Our ref: DOC21/122533  
Senders ref: SSD 10438 (City of Sydney)

**Response to Submissions – Waterloo Metro Quarter OSD – Basement Car Park Detailed Design, Waterloo Station (SSD 10438)**

EES has reviewed the RtS table prepared by Urbis dated 15 February 2021 makes the following comments.

SSD10438
BASEMENT - LONGITUDINAL
SECTION 01

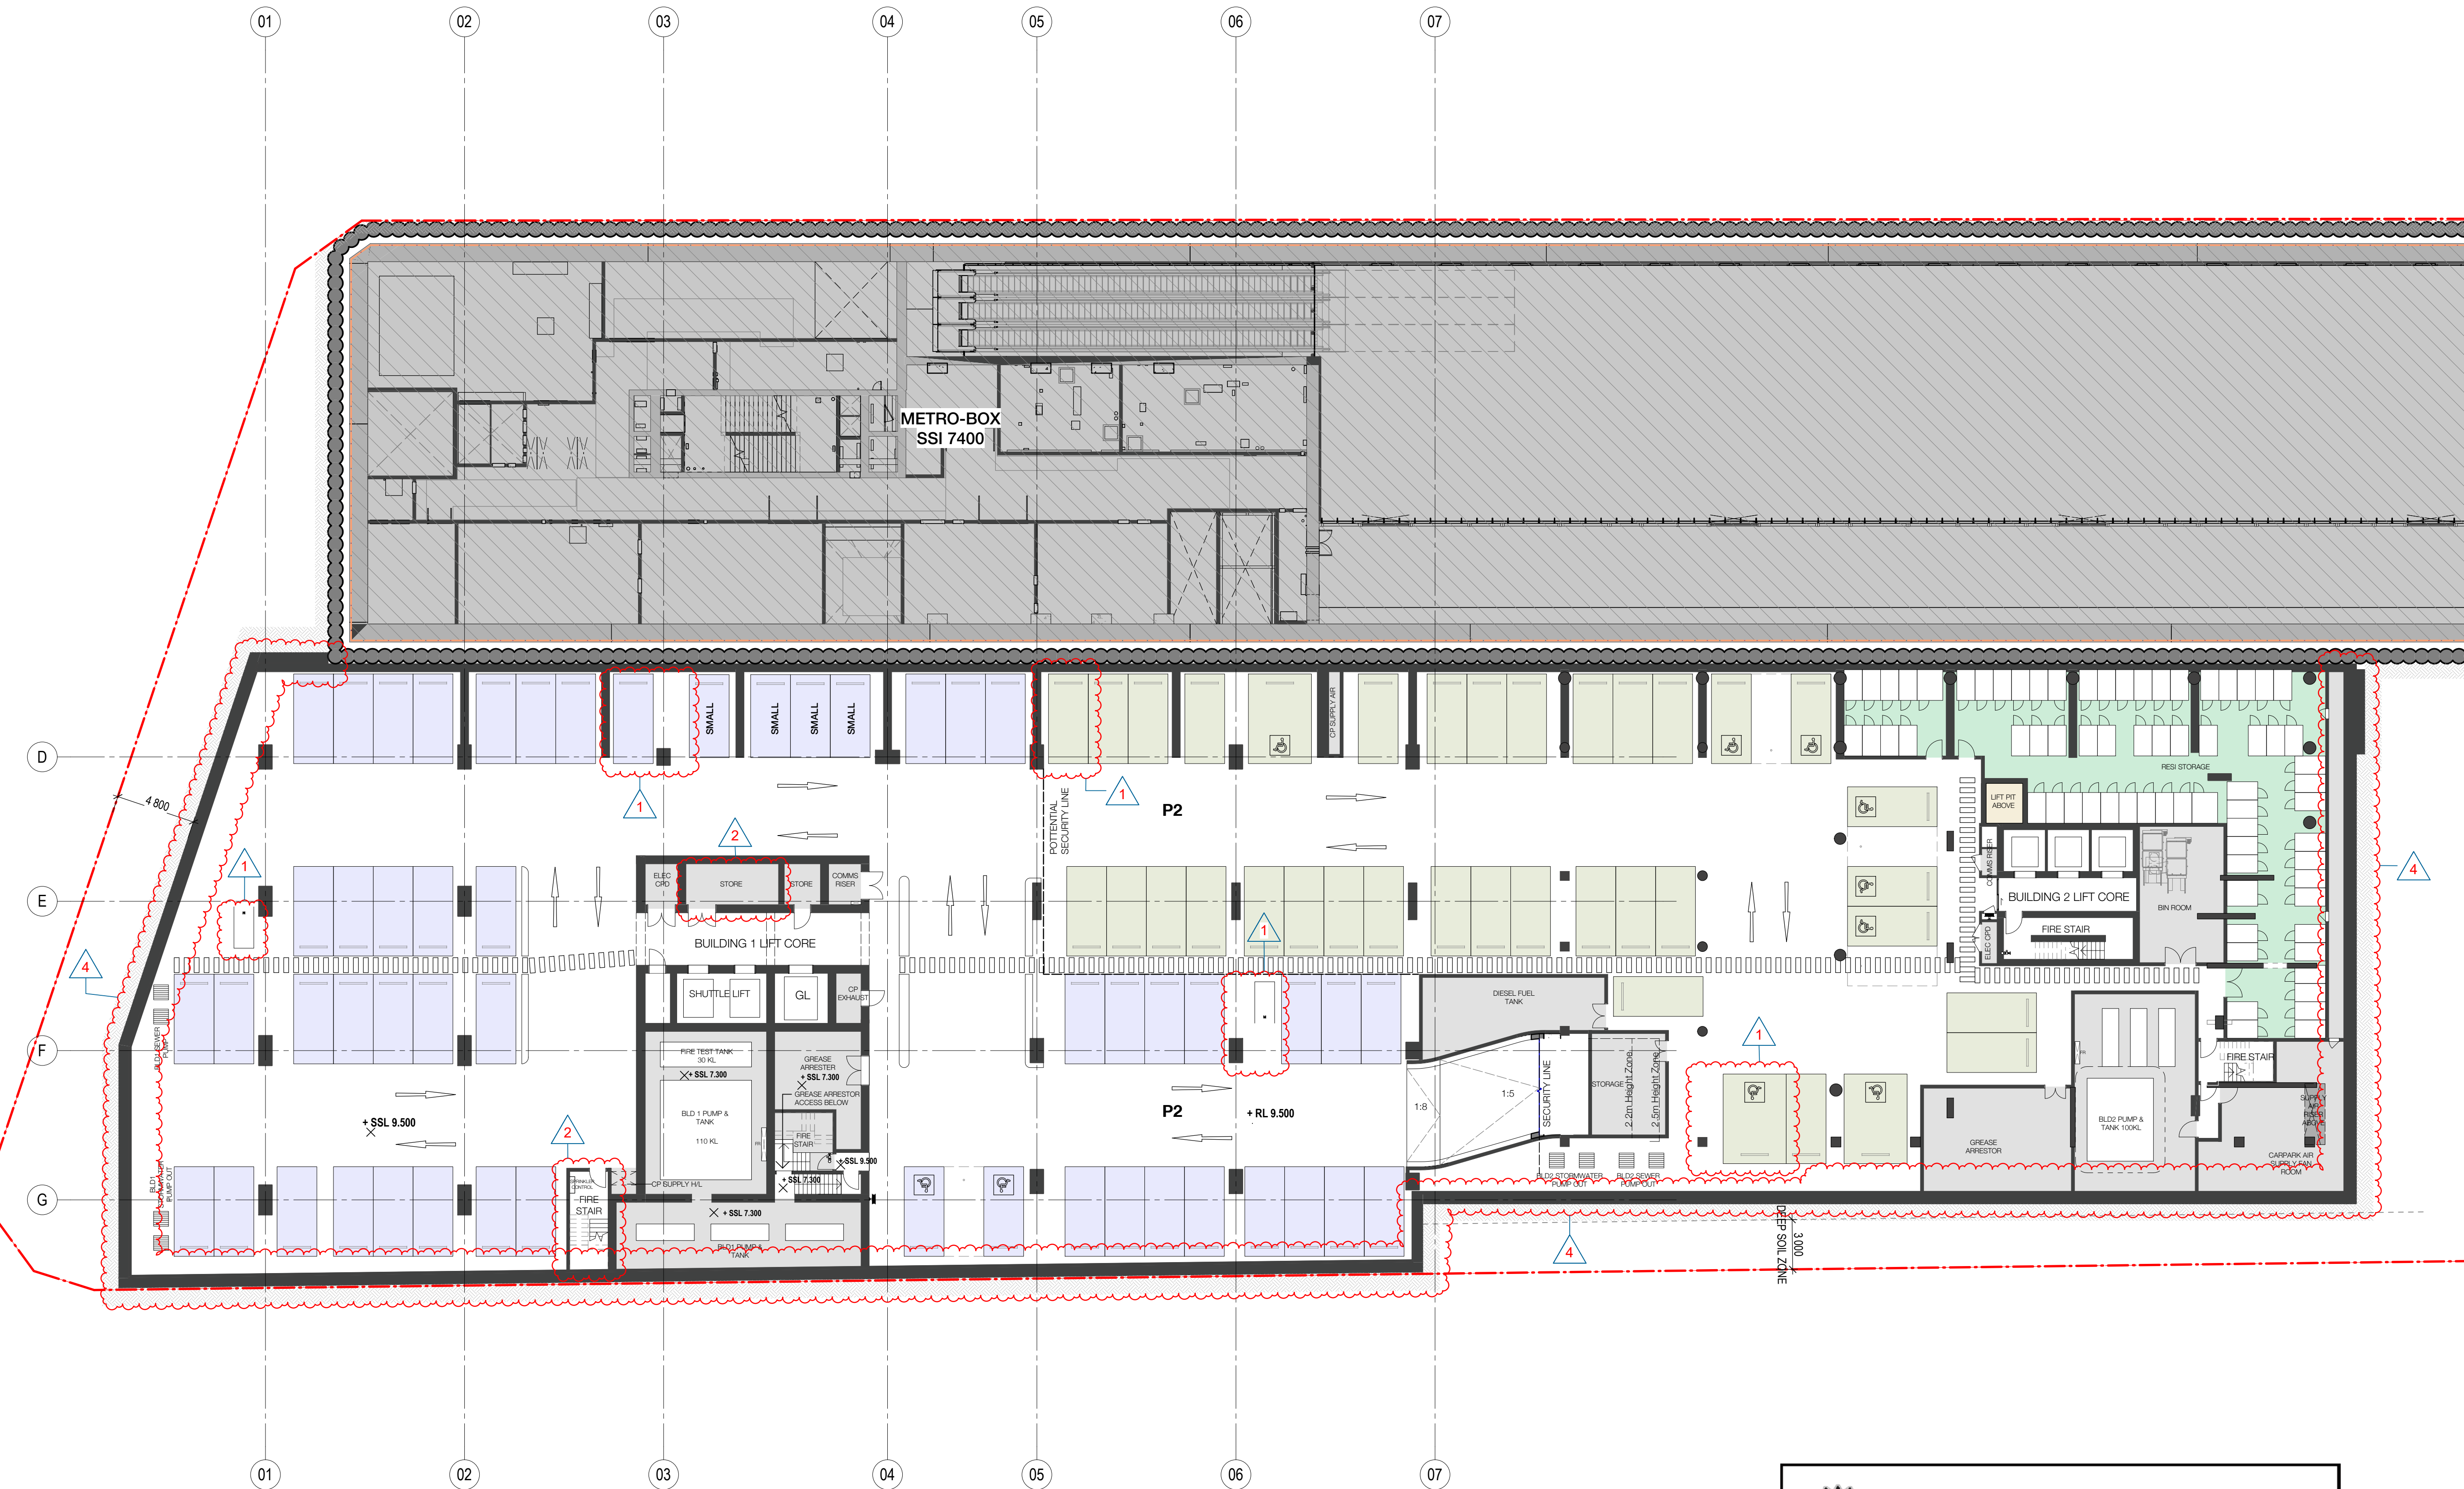
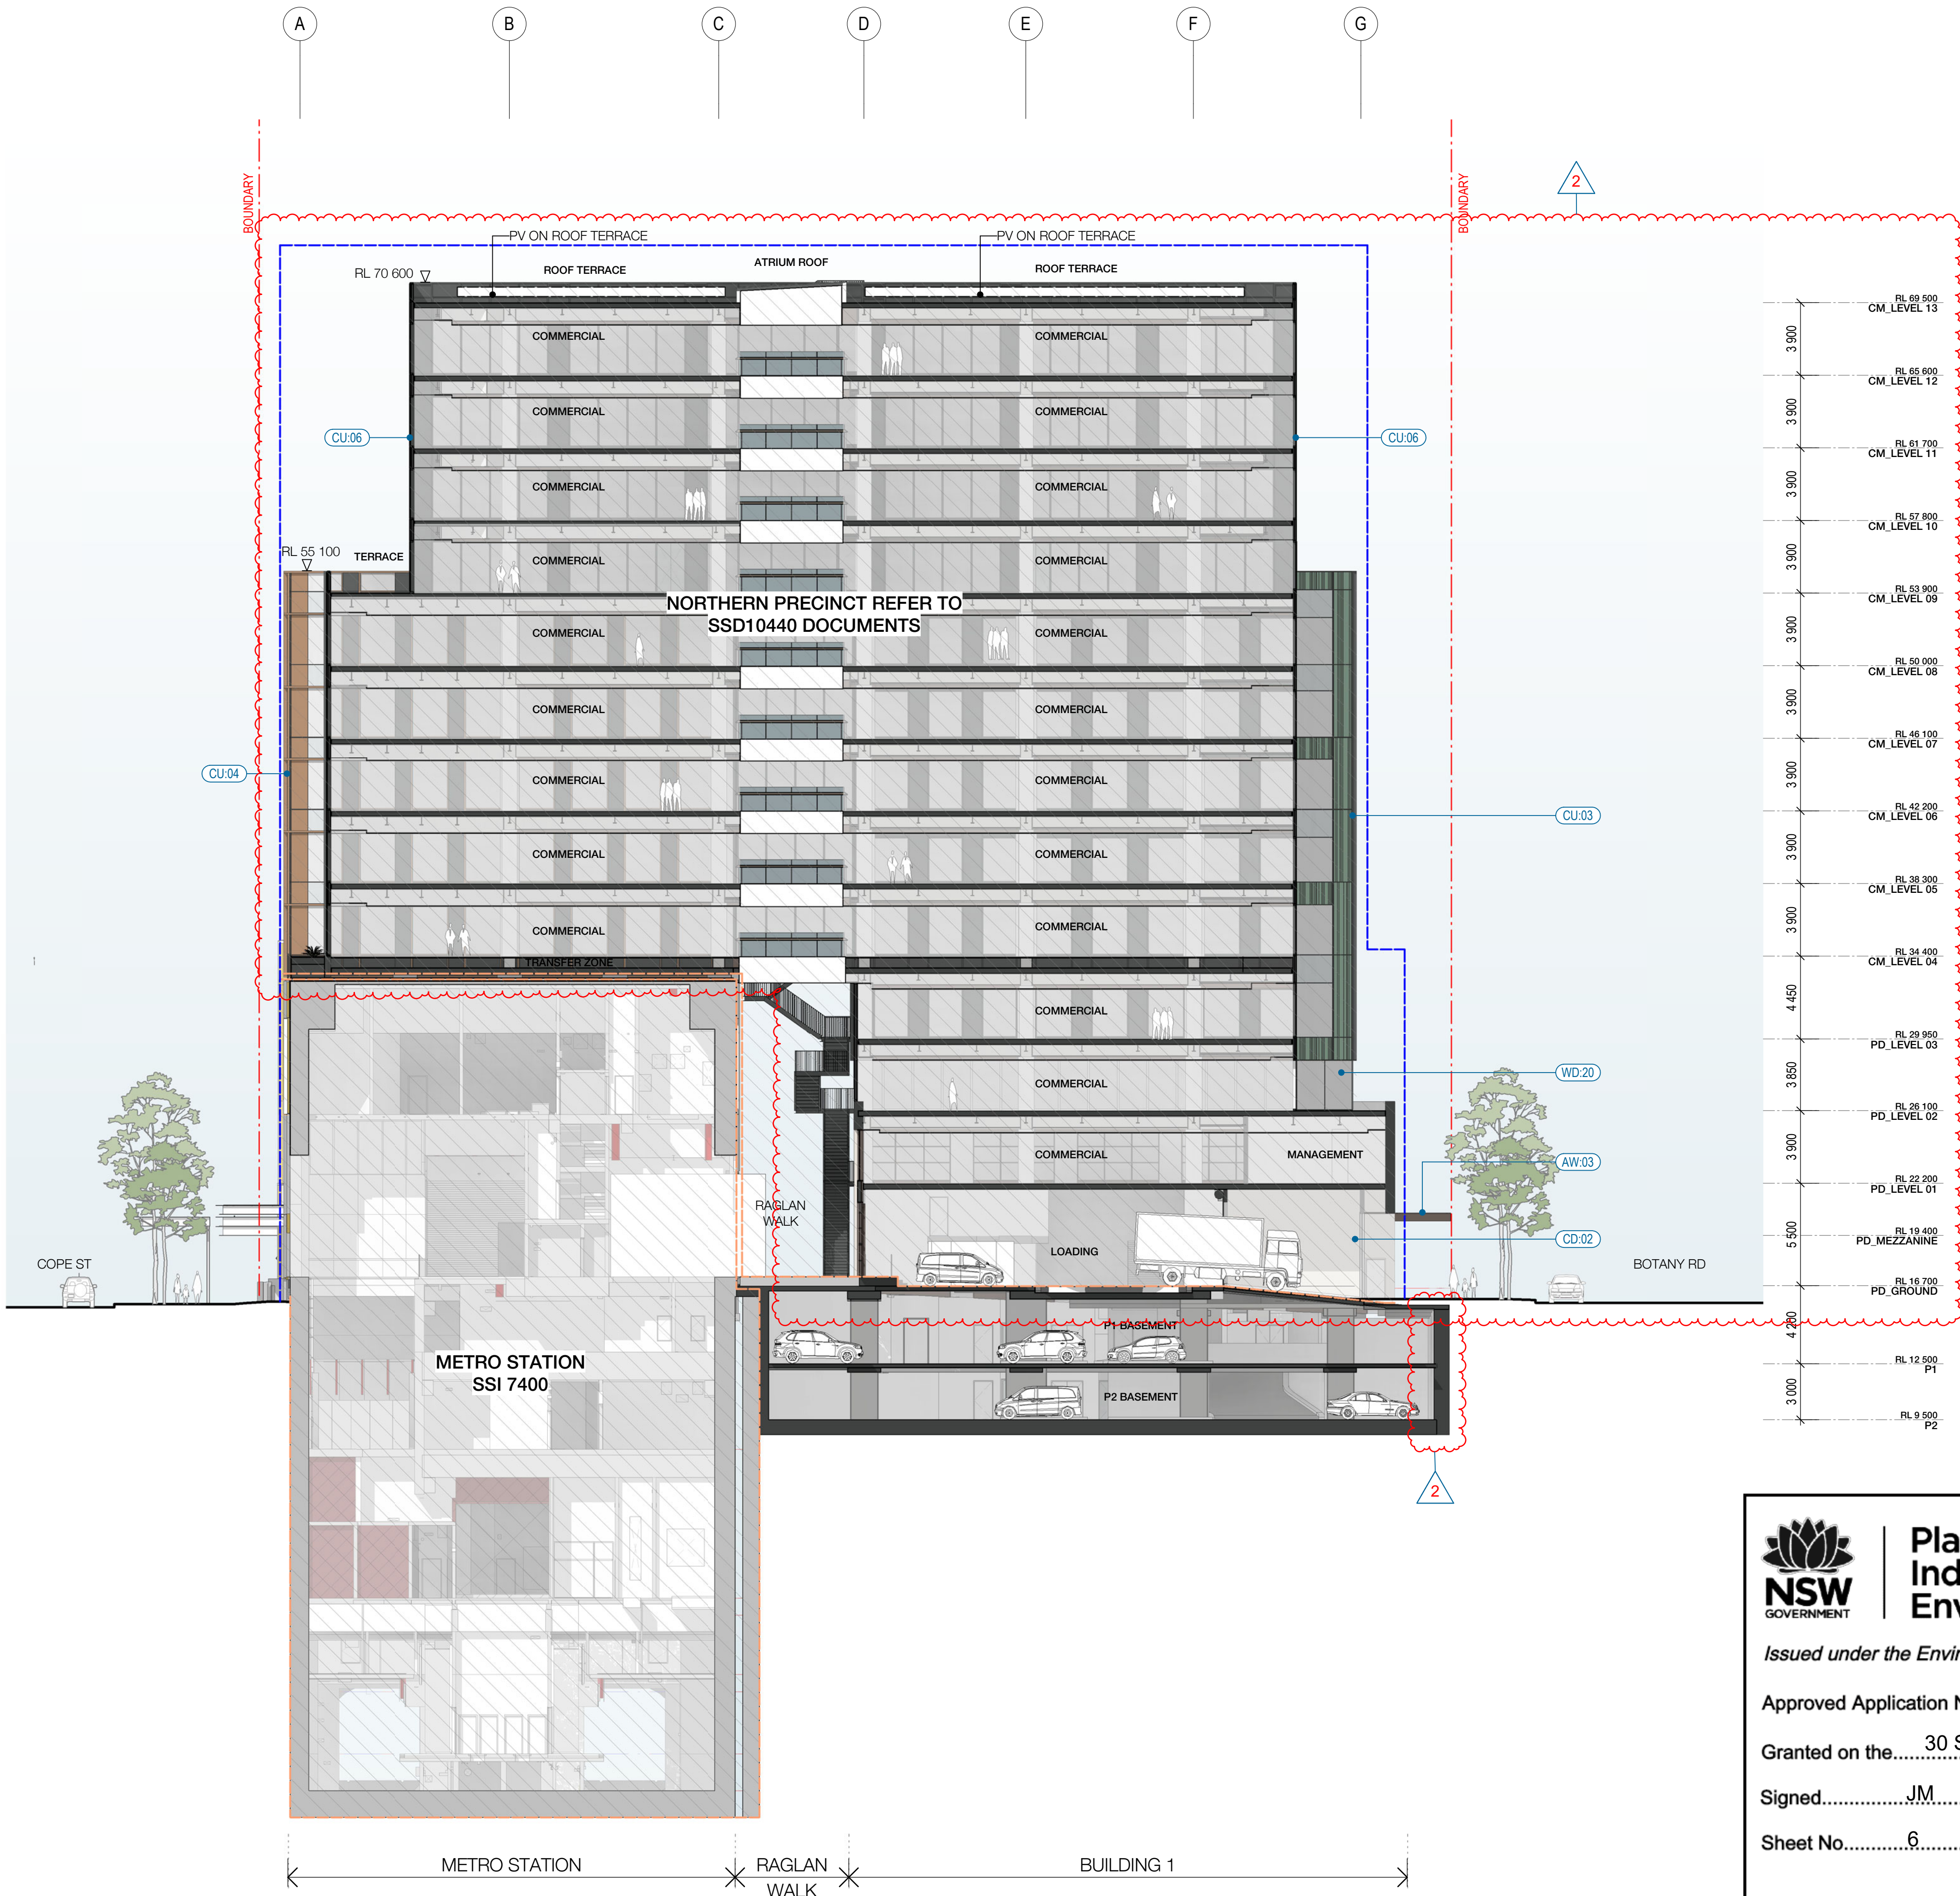
The RtS has not addressed EES's original comments dated 25 November 2021 (Ref Doc 20/918215) regarding residual risk and emergency management. The basement car park is not suitable for shelter during a flood and may impose risk to life during rarer events. It is recommended that a condition of consent require the development of a flood emergency management plan, including an egress from the basement to ensure safe evacuation. The latter may require a change to the building design to accommodate this egress.
